# ENG-SF19004-R3-FDR-Redlines Summary\_Markup Summary

# ENG-SF19004-R3-CD-Redlines Summary\_Markup Summary

# ENG-SF19004-R3-SC-CD-Redlines Summary\_Markup Summary

# ENG-SF19004-R3-GEC-Redlines Summary

LOTS 36-41 STORM SEWER (PRIVATE)
SCALE 1"=30'

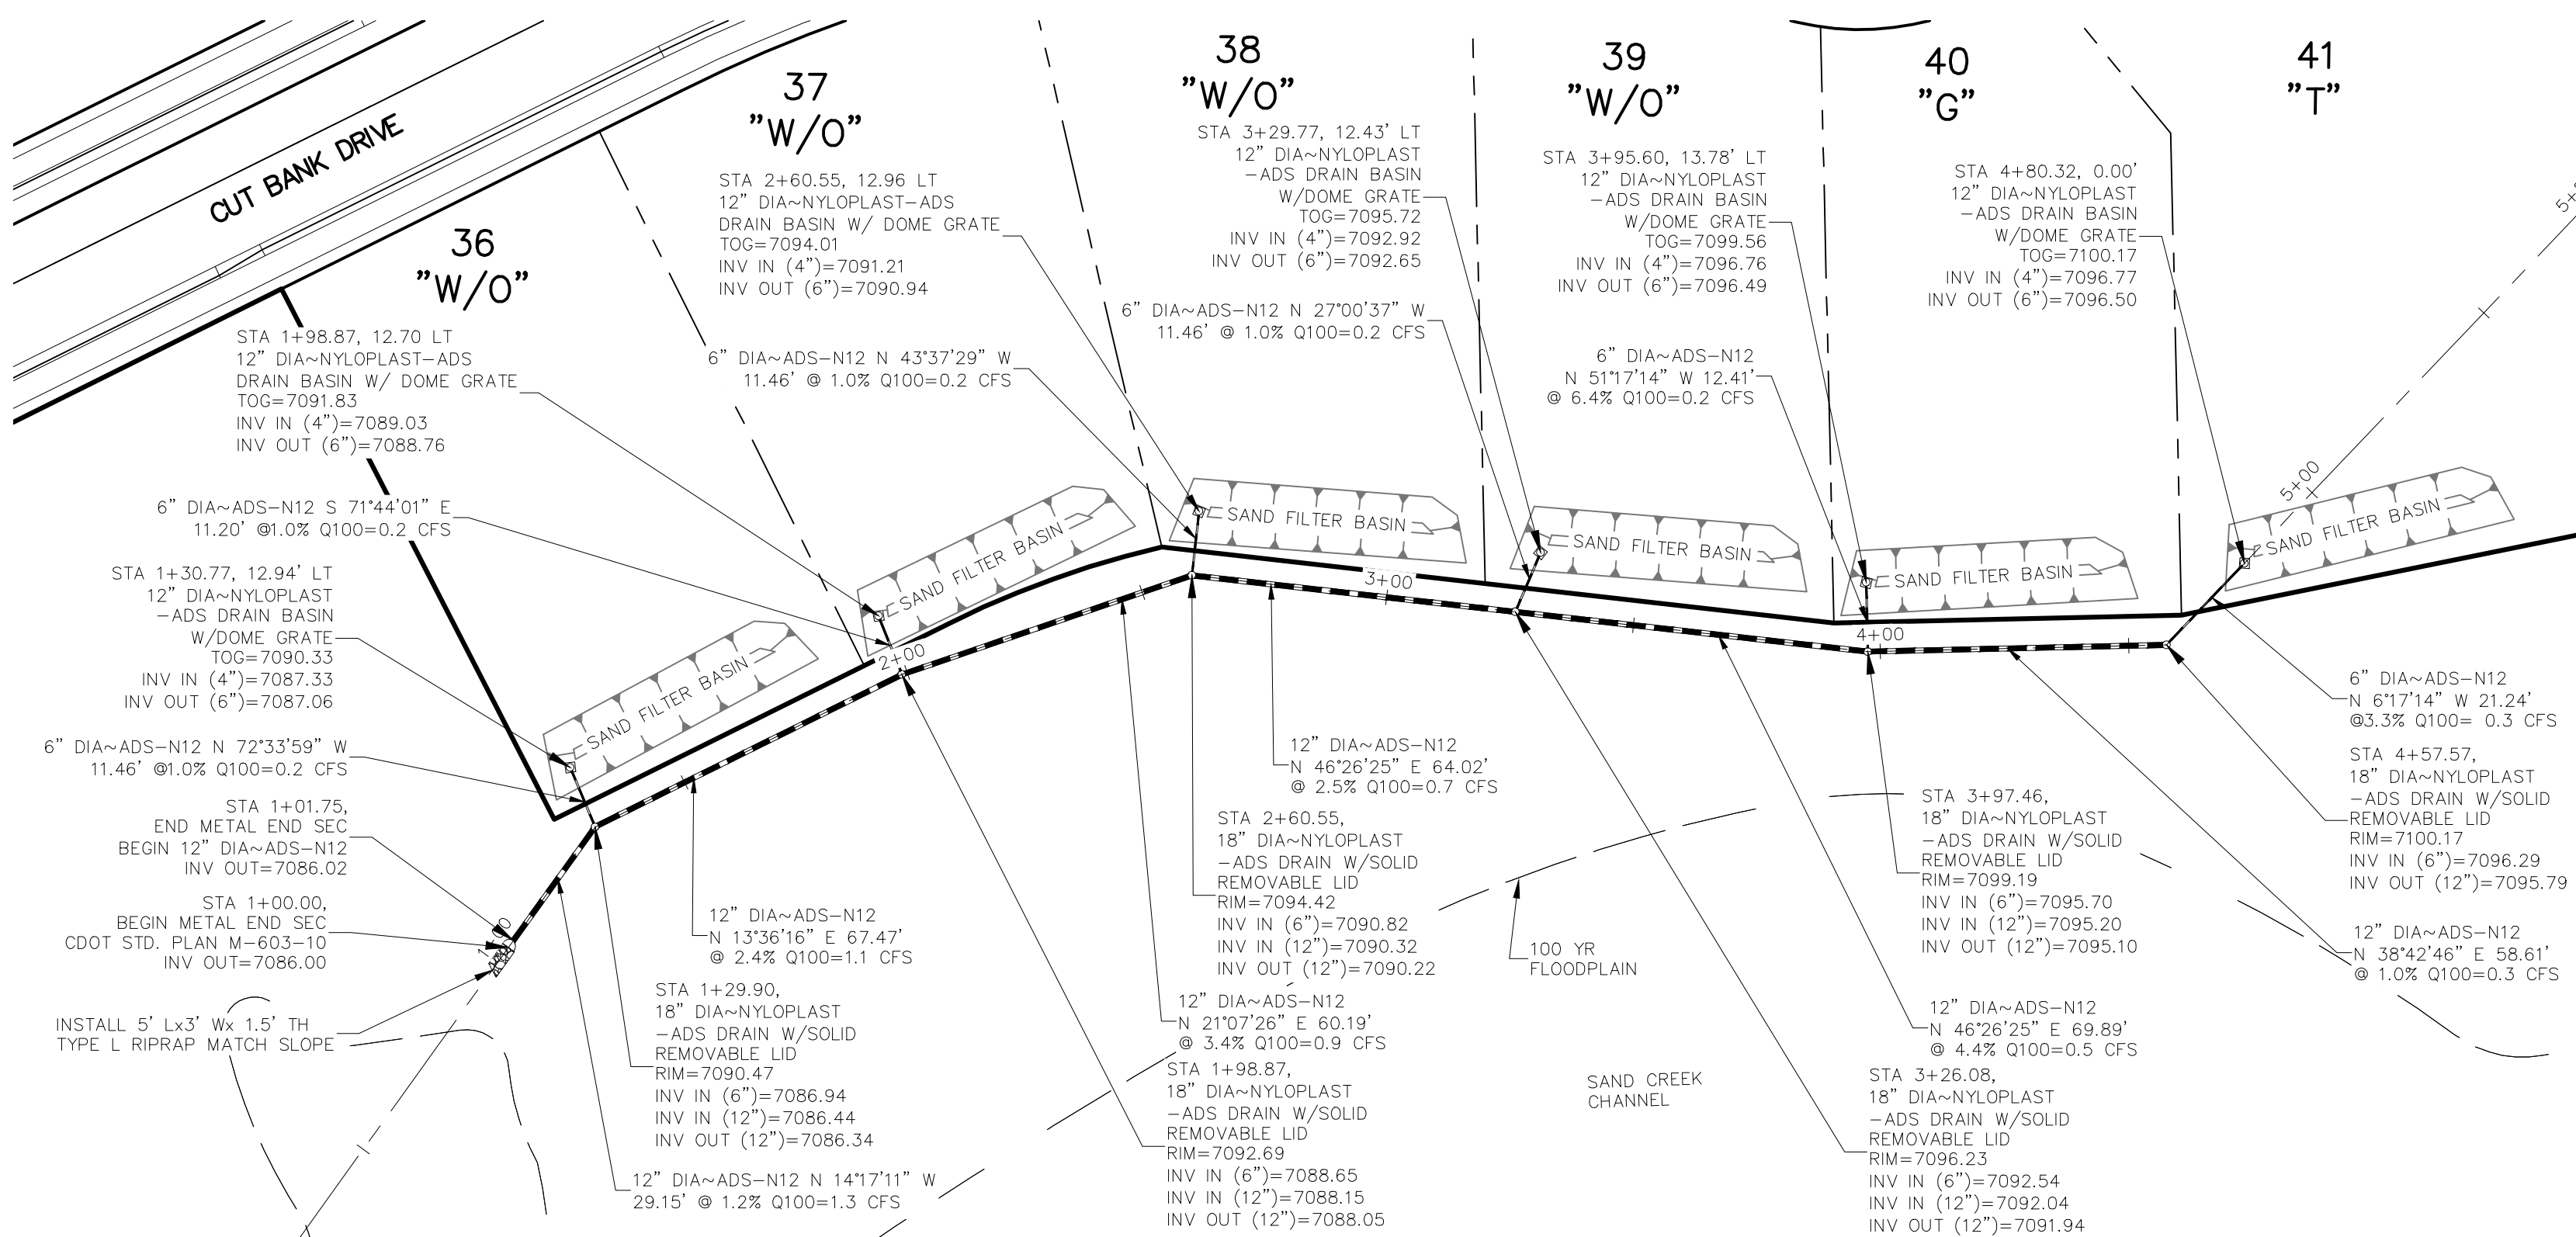
Add a more specific detail for the 52 SFB's that will be used for back yard WQCV. Since all 52 will be similar, provide the outlet structure detail, the outfall pipe sizing information, Fencing, (Split rail fence), etc.
